Please place this attachment of my letter objecting to the DNS on the Grow Bros. marijuana production and processing facility on Rader Road.

Re: SEPA application for Grow Bros. on 2990 Rader Road, Ellensburg, WA

ENLARGED SITE PLAN

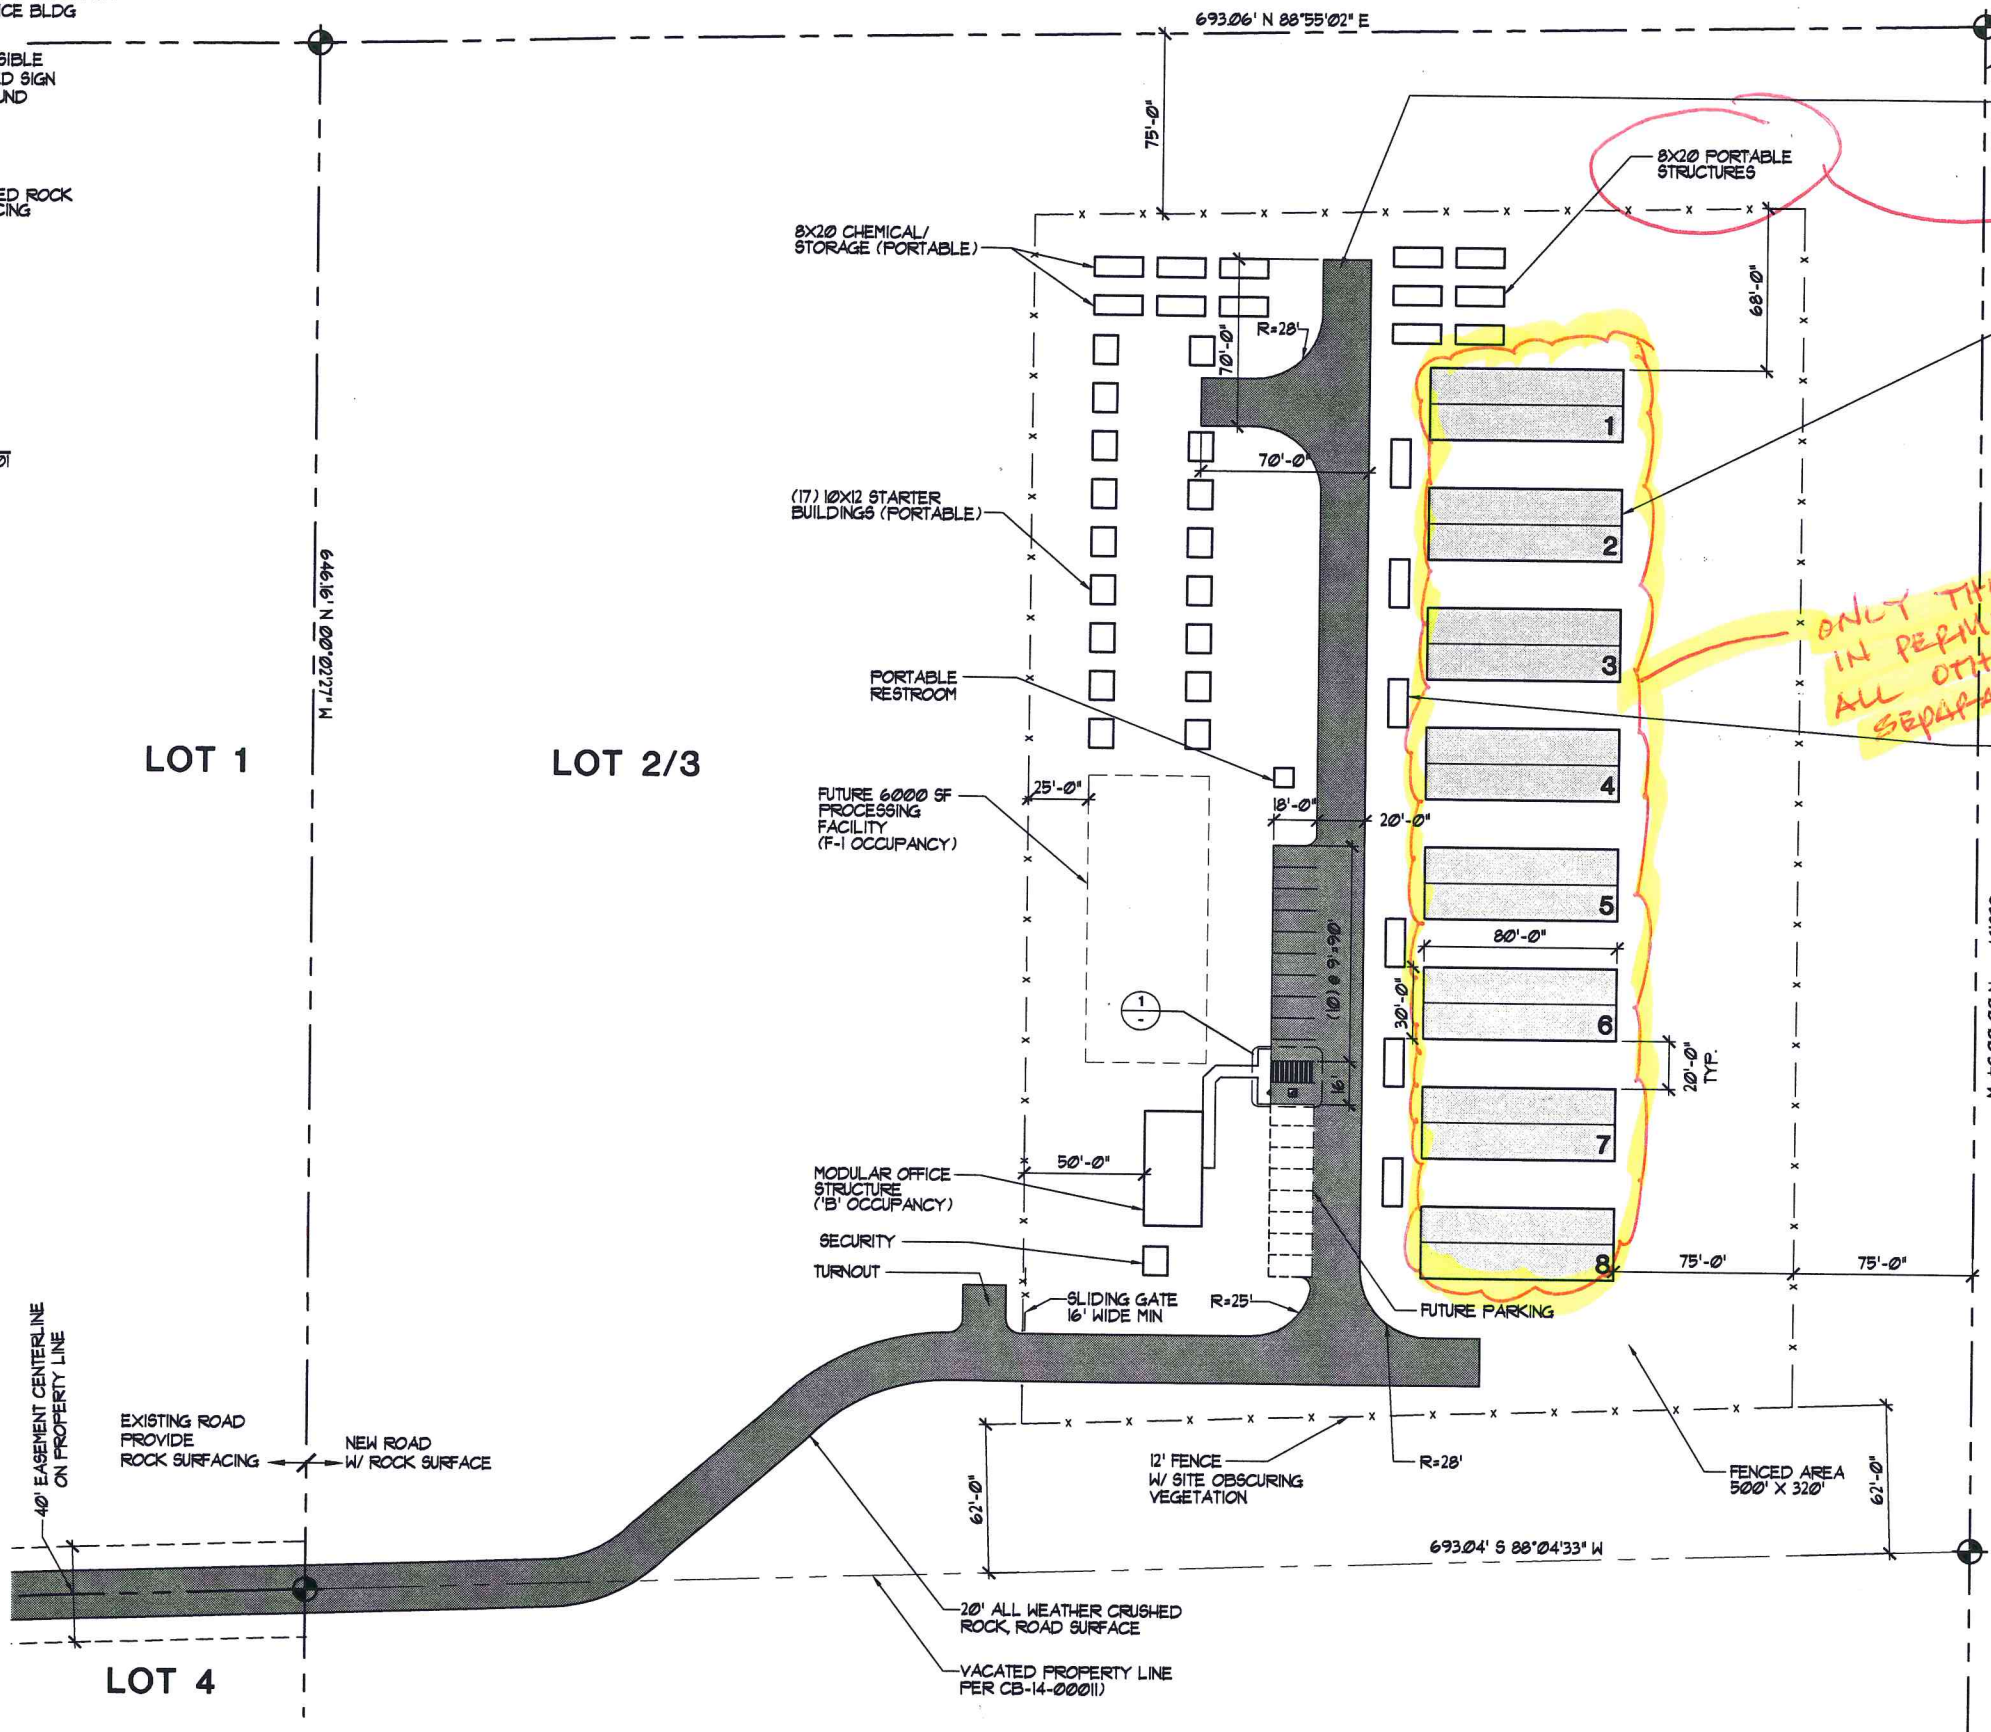
- b) There are 19 parking spaces on phase I alone and another 19 on phase II. Who is going to be using all these spaces?
 - c) They are clearly setting themselves up to have a second Tier 3 grow operation as well as a processing facility.

- a) There are no bathrooms planned.
 - b) They say the employees will use porta potties.
